CVI LASER STORAGE BLDG.  
MOLZEN-CORBIN & ASSOC. 1-2-88  
242-5700  
(L-22/D-4)

RE: CVI LASER STORAGE BUILDING  
(L-22/D4)

I am writing in response to your request for a waiver of our requirement of an updated drainage report as a condition for this department's sign-off on the Certificate of Occupancy.

CIVIL ASER STORAGE BUILDING

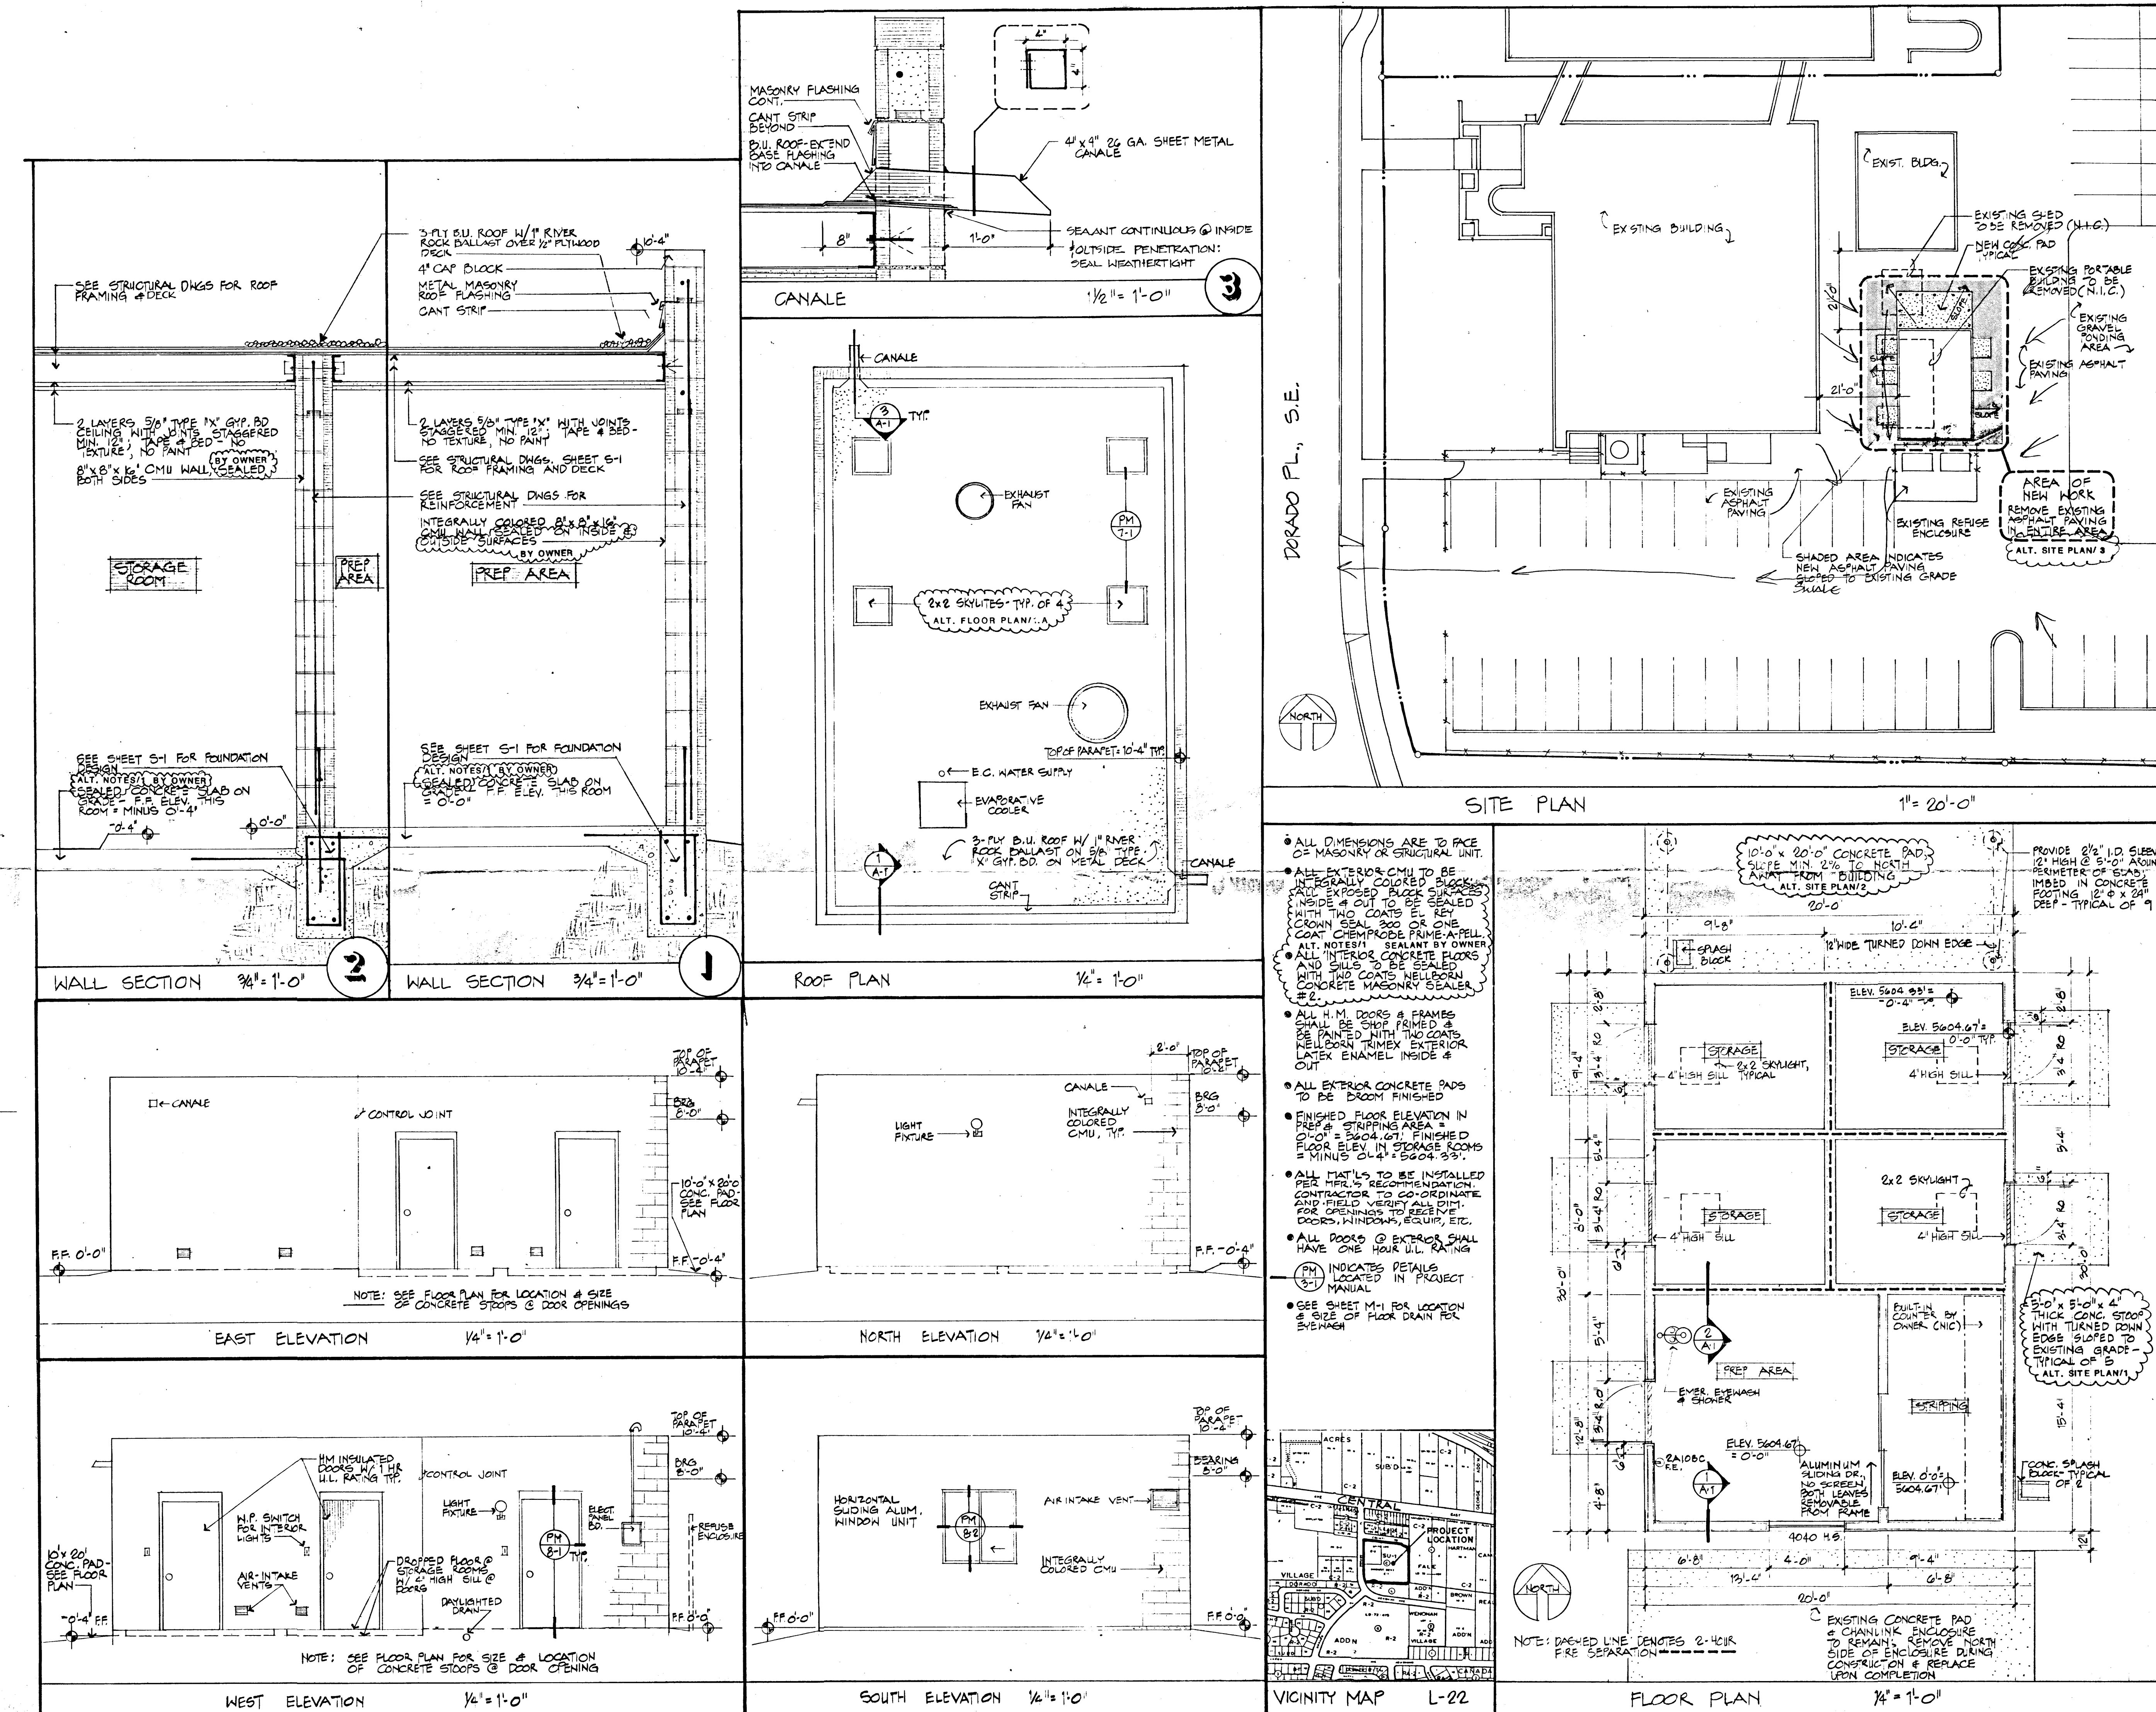
Our survey of the site has convinced me that the site is in substantial compliance with the drainage plan on file. The only apparent problem is that there is an existing paved swale ditch which will be covered up by the new paving and the new building. Your site plan does not make it obvious to the contractor that he will have to deal with a drainageway which he must not block.

If you will revise your drawing to insure that the contractor understands the drainage of the area and his responsibilities, we will be satisfied. Copies of the revised drawing must be attached to the City Building Plans on file with Code, and sent to the contractor and to us for our file. I have taken the liberty of marking a copy of your present submittal as a sample of what I had in mind.
